Your Ref	SSD-31179510
Our Ref	NCA/9/2022
Contact	Paul Sartor
Telephone	9806 5740
Email	psartor@cityofparramatta.nsw.gov.au

**NOTICE OF EXHIBITION OF ENVIRONMENTAL IMPACT STATEMENT FOR THE
GREGORY PLACE BUILD TO RENT SCHEME (2A GREGORY PLACE, HARRIS PARK)**

ATTACHMENT 1 – Detailed Comments

FIGURE No. **10**

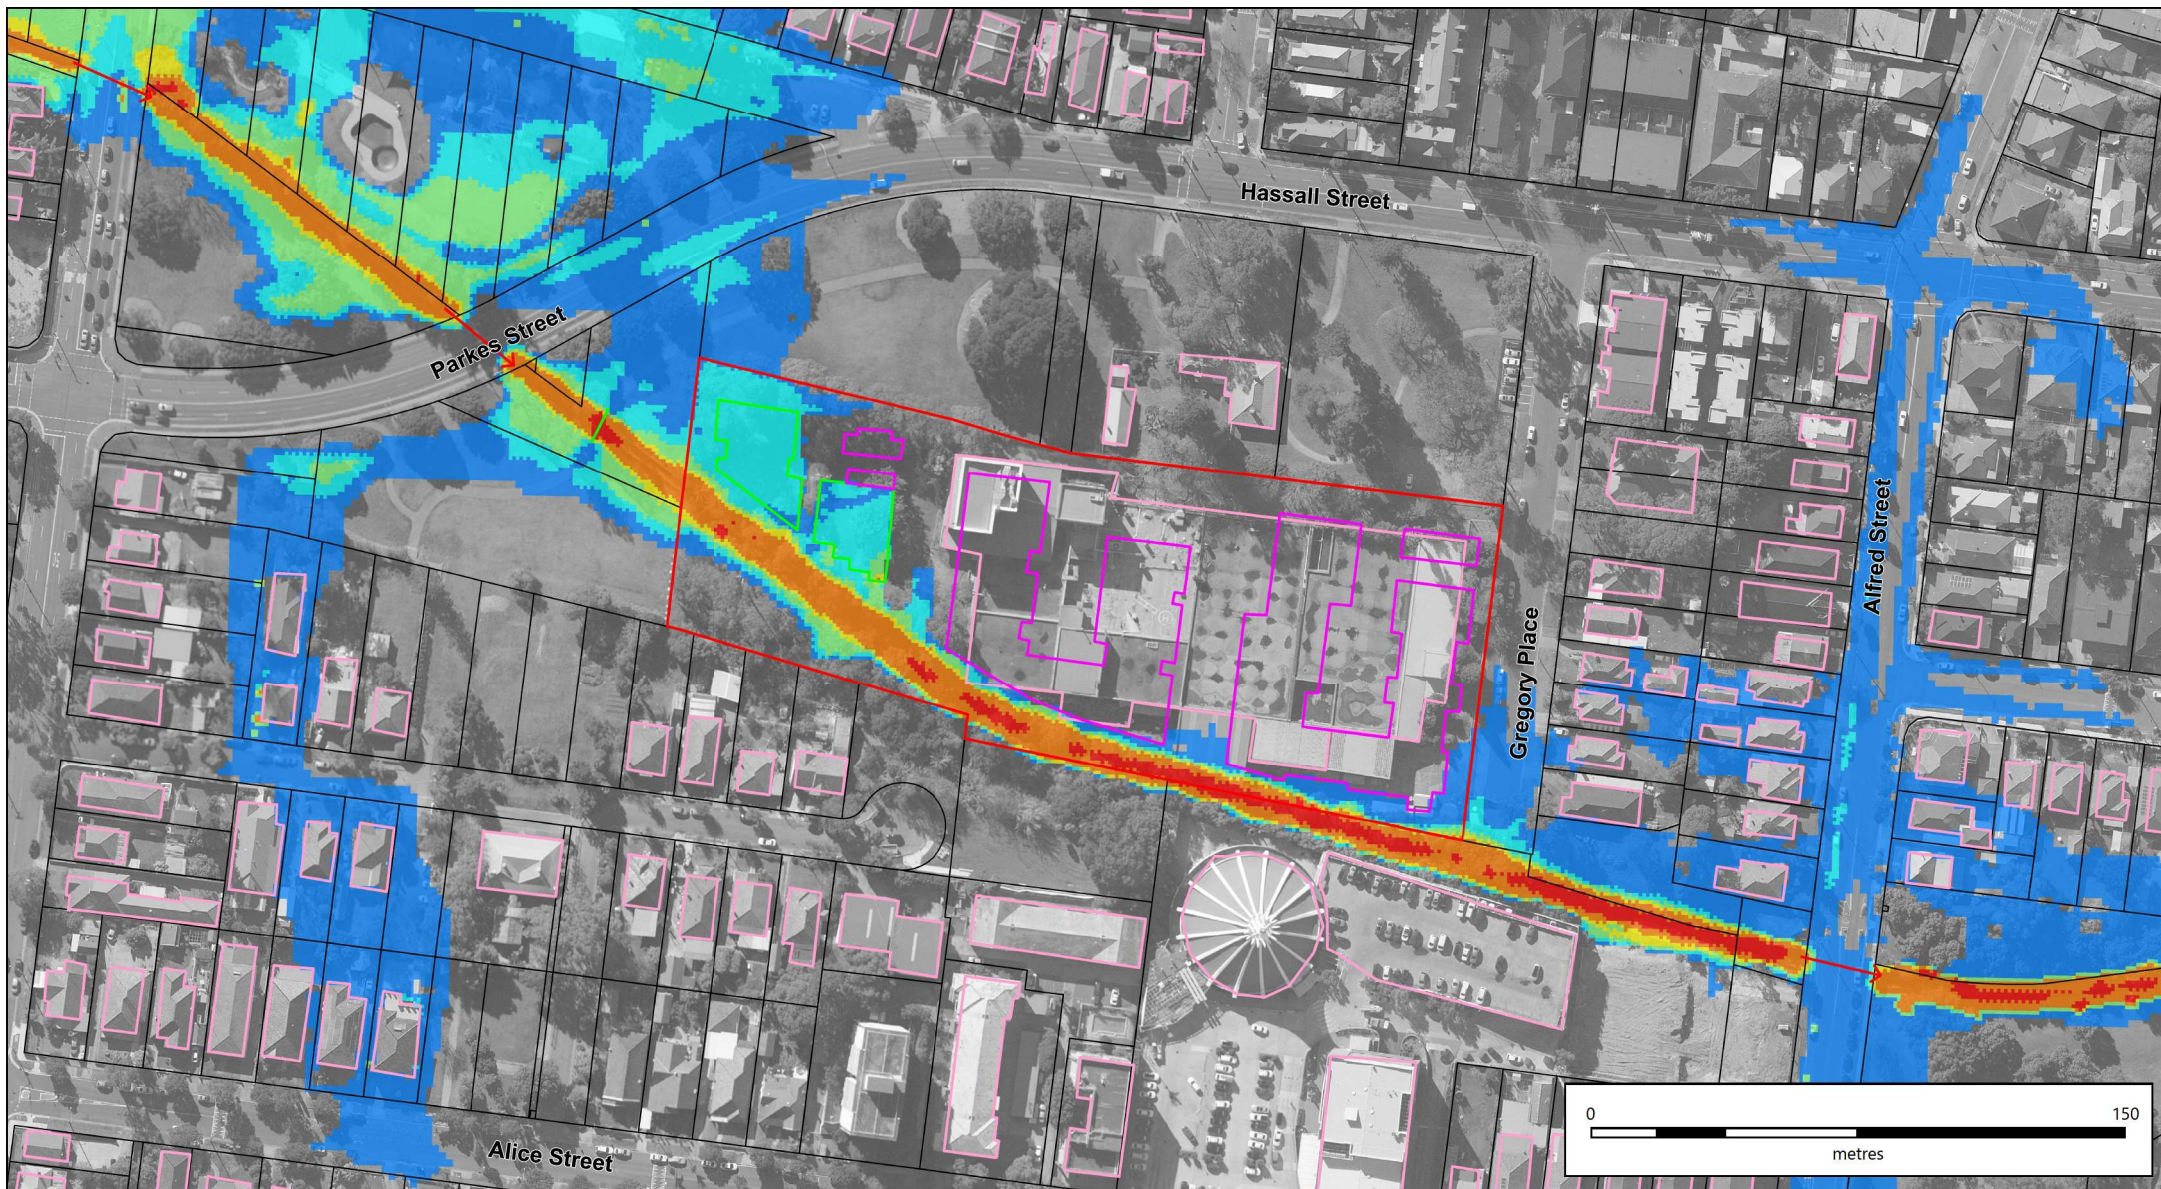
- j. The building footprints shown on the architectural drawing *Site Plan, Drawing No: CD 005* is significantly different to the footprints shown in the submitted Flood Study by GRC Hydro (1% AEP Peak Hazard Conditions, Figure No 11). The boundaries of Building C appear to have been modified. The modelling of building footprints should be reflected in the flood study as per architectural drawings. Any differences in the building footprint will lead to misrepresentation of flood behaviour and likely to cause undesirable flood impacts.
Action: Amend building footprints as per the latest architectural plans and update flood modelling as necessary.

City of Parramatta Council Flood Map

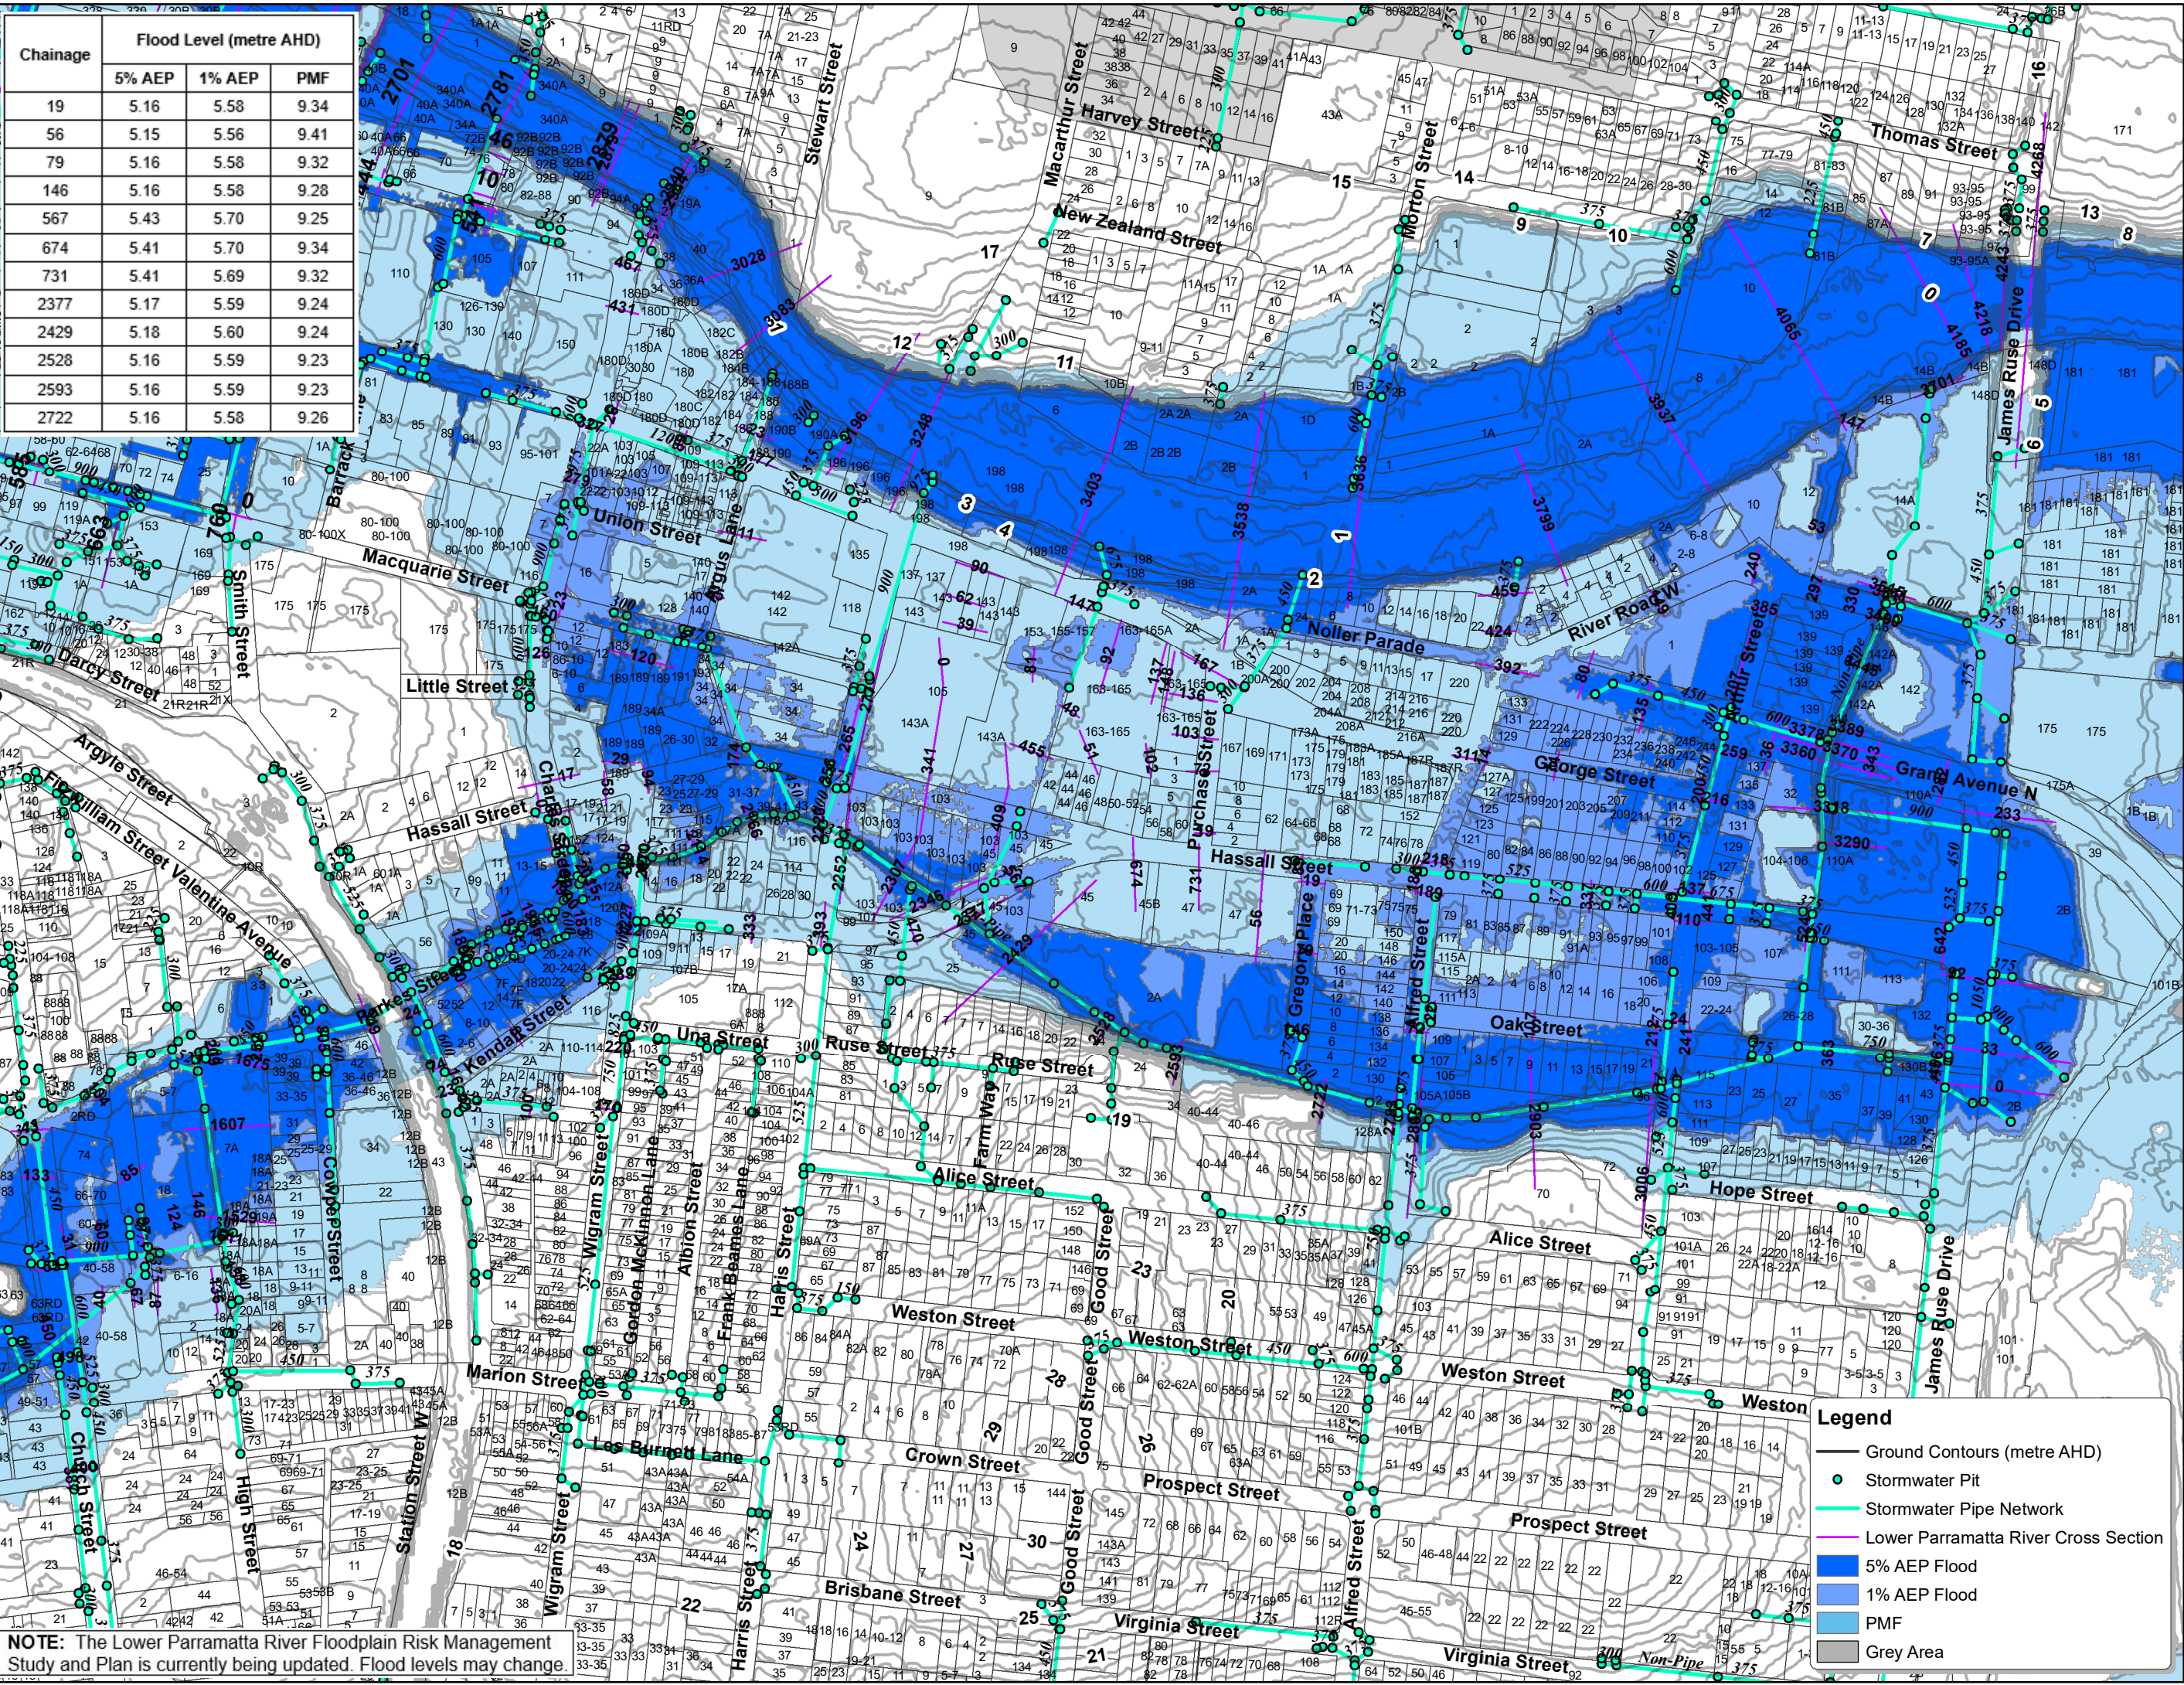
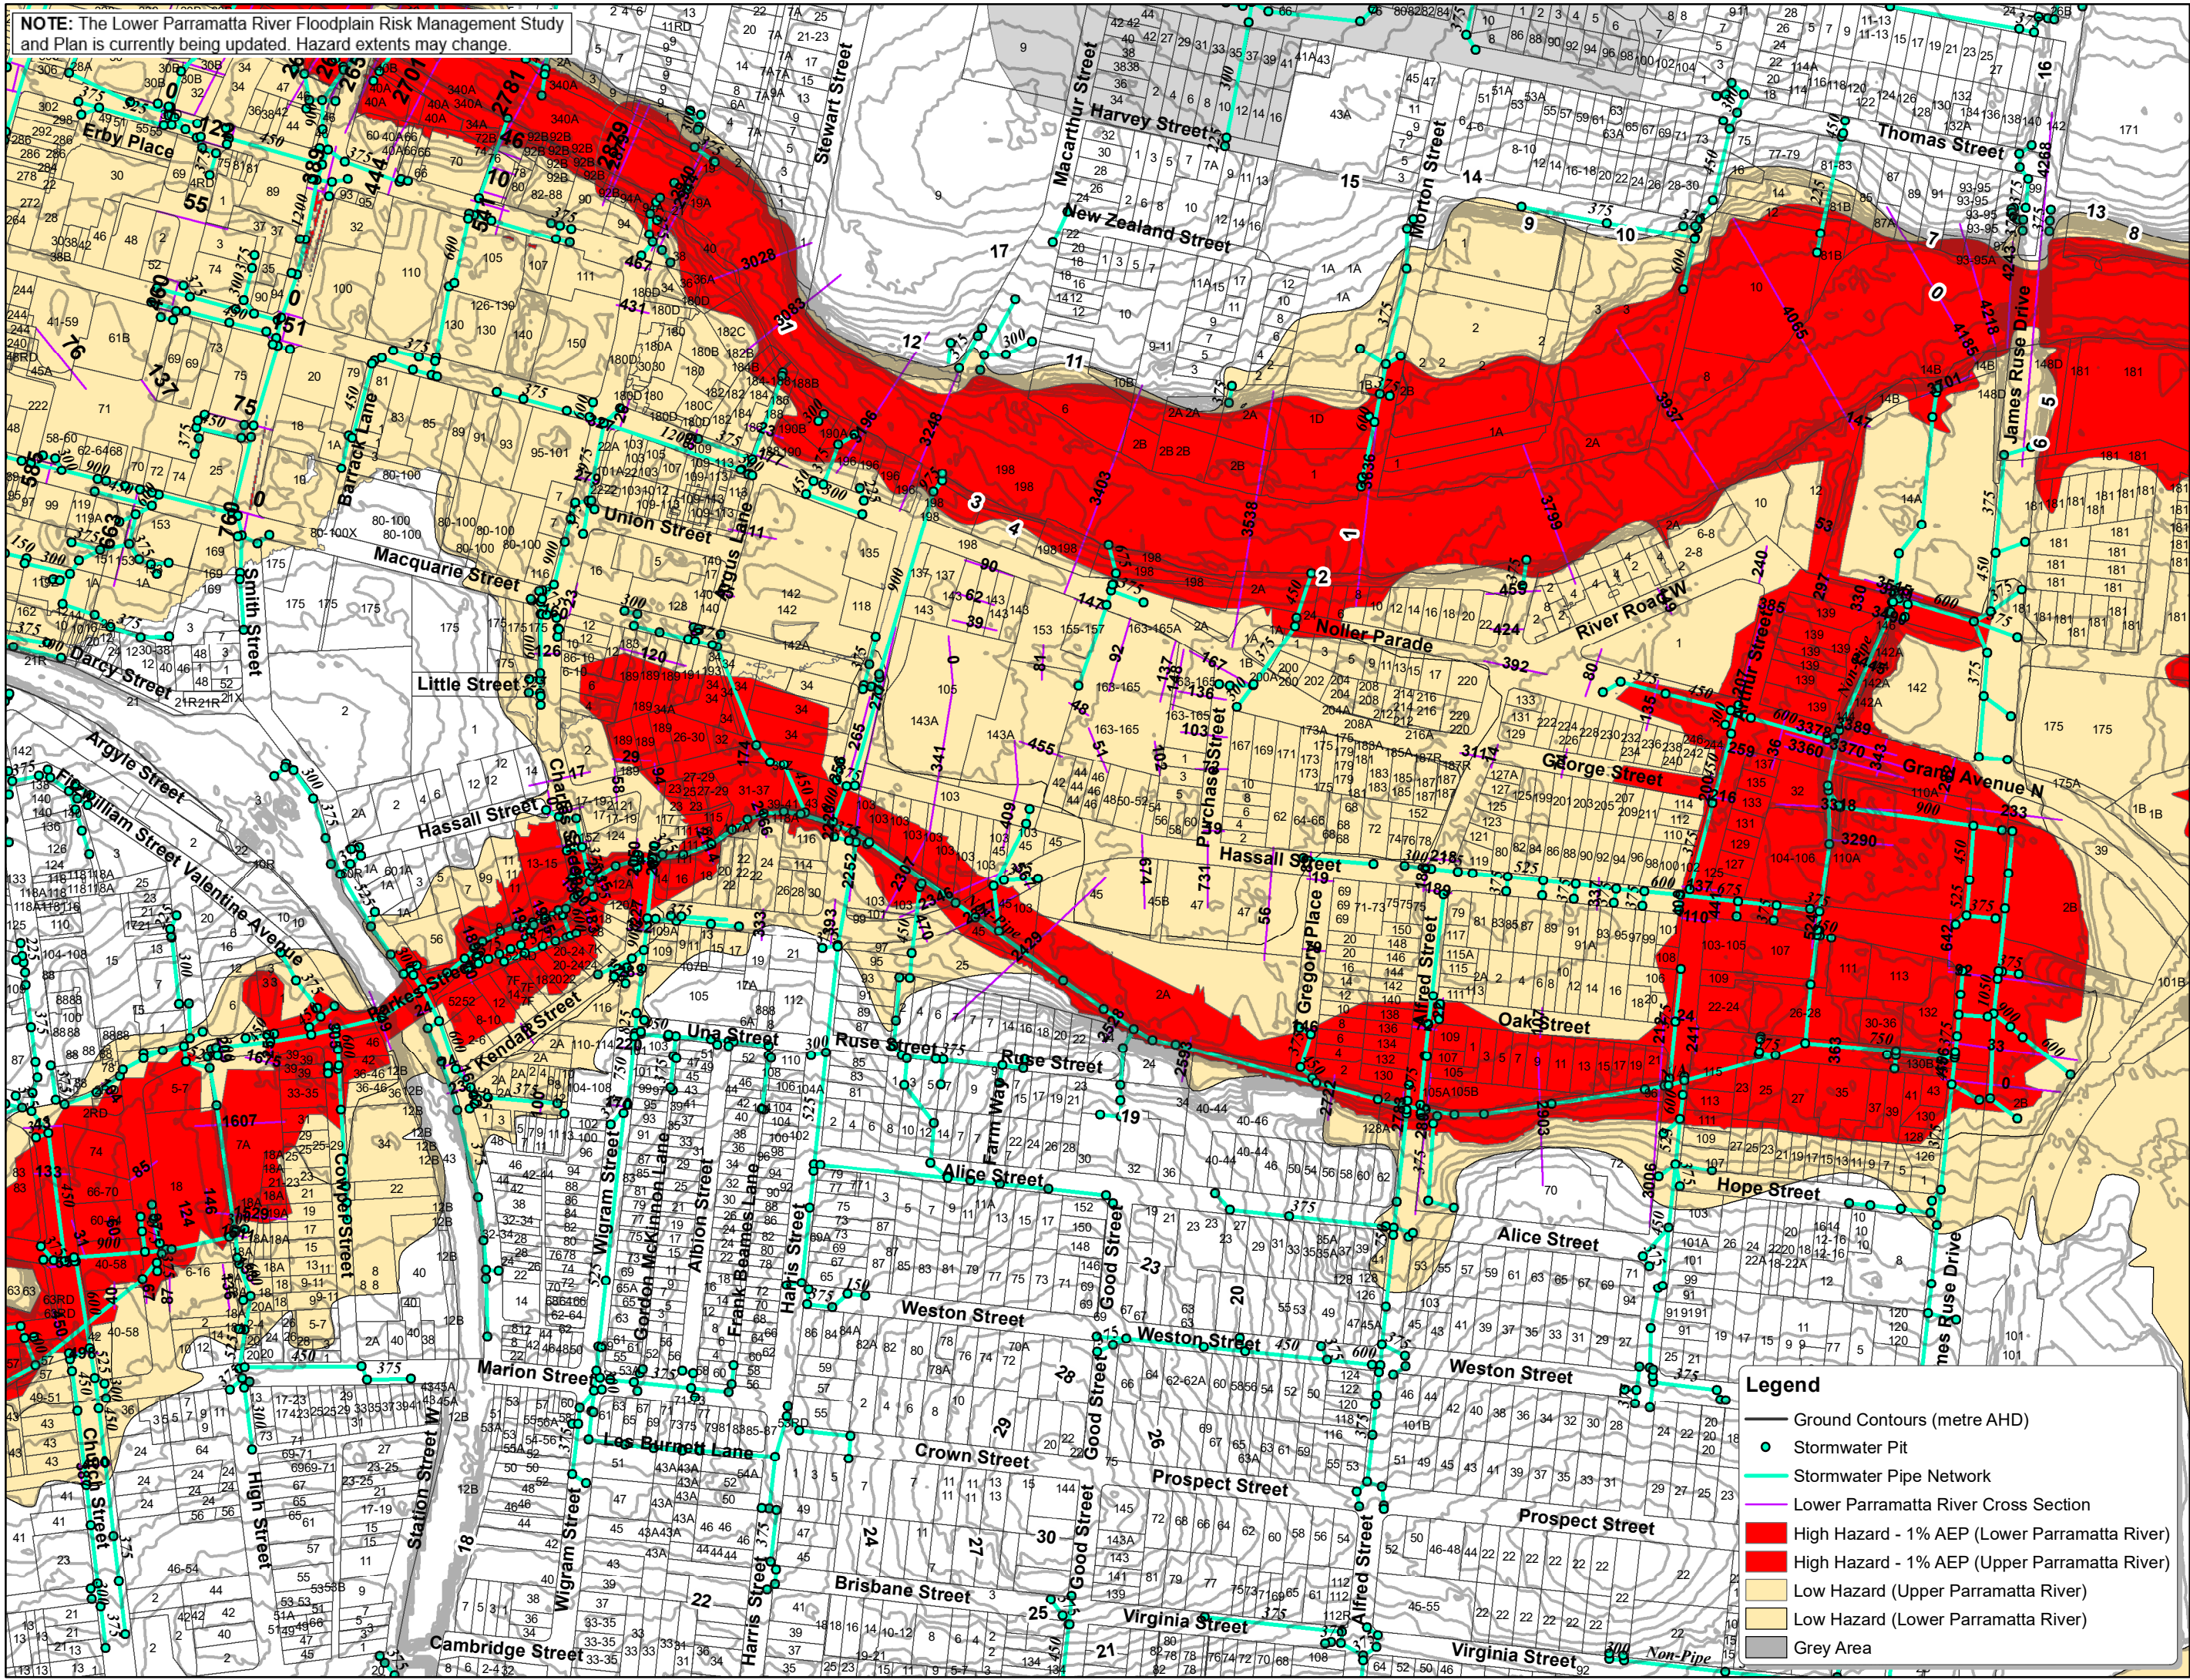
- a. The flood maps provided in the report have significant differences in terms of the flood extents and flood levels. A comparison between Council's Flood Enquiry Information vs. the Flood report prepared by GRC Hydro, dated 16 June 2022. 1% AEP flood extent is attached. Refer to [Appendix 1](#). The extent of flooding along Gregory Place, Alfred Street and Hassall Street are significantly less in the GRC Hydro Report compared to the adopted Council Flood Study which should be investigated.

Action: The consultant should compare flood extents and investigate the differences; the submitted models should be independently peer reviewed by a suitably qualified engineer/flood modeller. The results of the peer review should be documented and submitted to Council.
